# CITY OF PORTLAND BUILDING PERMIT

Job ID: 2011-02-404-ALTCOMM

has permission to Renovate Units B & C, common areas for temporary in-law situation, update insulation, kitchen & basement provided that the person or persons, firm or corporation accepting this permit shall comply with all of the provisions of the Statues of Maine and of the Ordinances of the City of Portland regulating the construction, maintenance and use of the buildings and structures, and of the application on file in the department.

**Jeanie Bourke - Re: 39 cumberland renovation project upgrades**

FLOOR PLANS  
1ST FLOOR  
BASEMENT PLAN

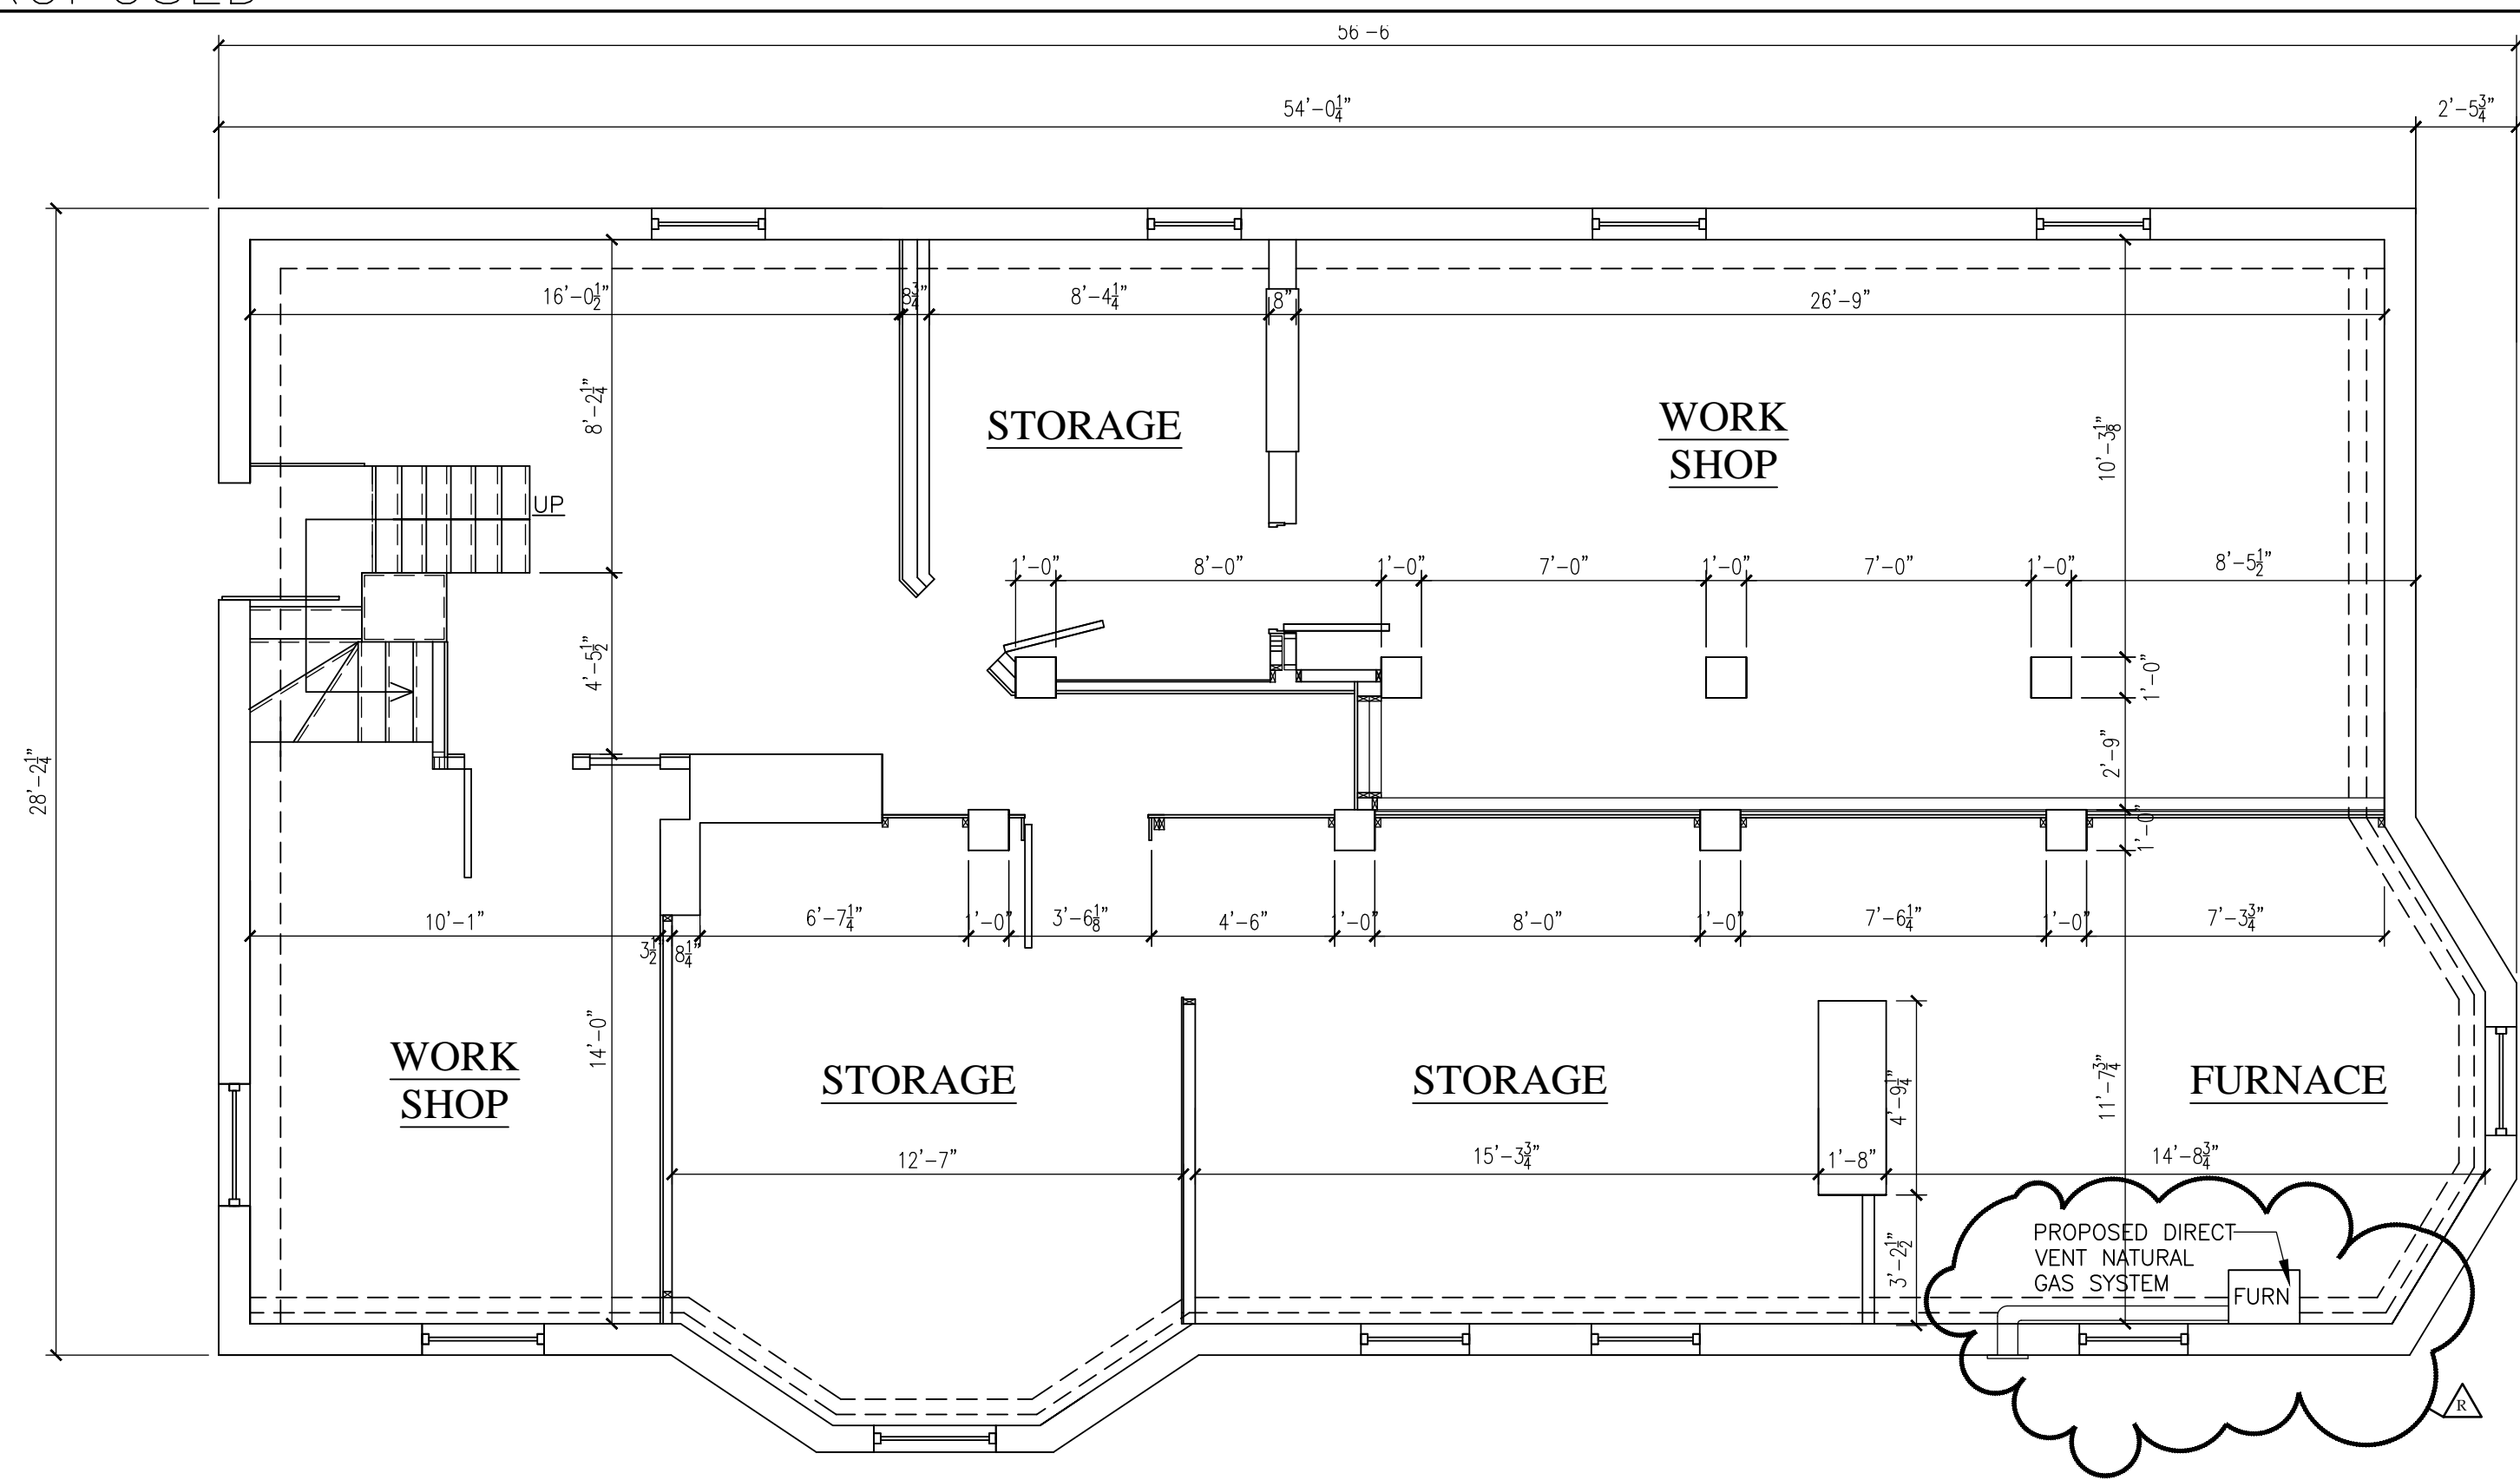
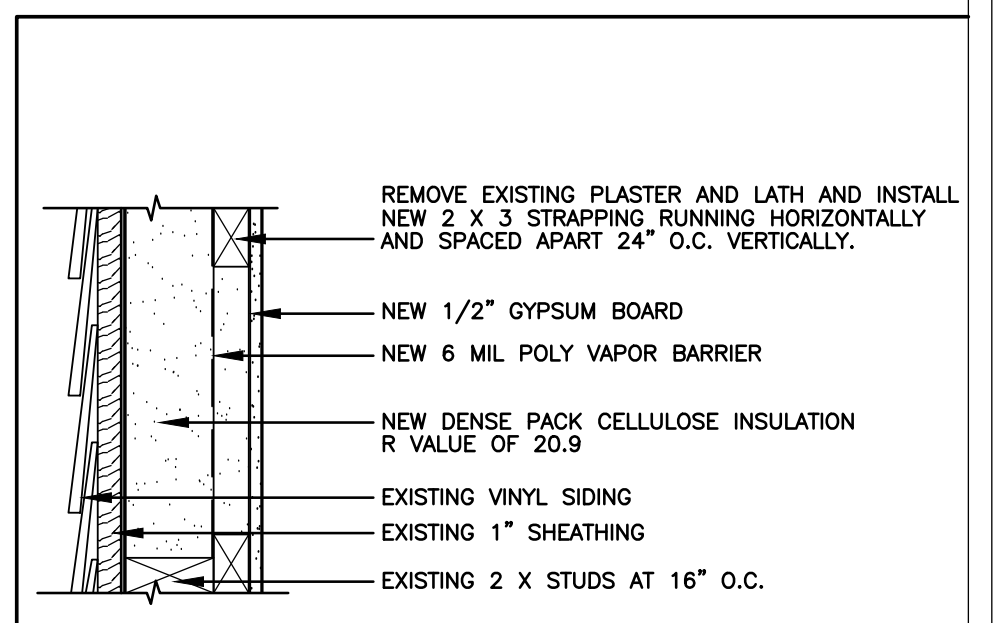
1. the north interior walls included in this renovation will be finished in fire-grade drywall.
2. the **cellar ceiling** will finished in drywall to a 50 STC is the sound rating. The drywall will be type x or c / **two layers** with a 2 hr separation.
3. the cellar entry door will changed out to be fire door.
4. the walls of dumbwaiter will covered in fire grade drywall.
5. a fire grade drywall partition will be installed with the dumbwaiter
6. the furnace room will be smoke proof.
7. the floor 3 bath window will be shatter proof tempered glass.
8. all openings between floors (wires, pipes, conduit, ducts) to be fire stopped with approved materials.
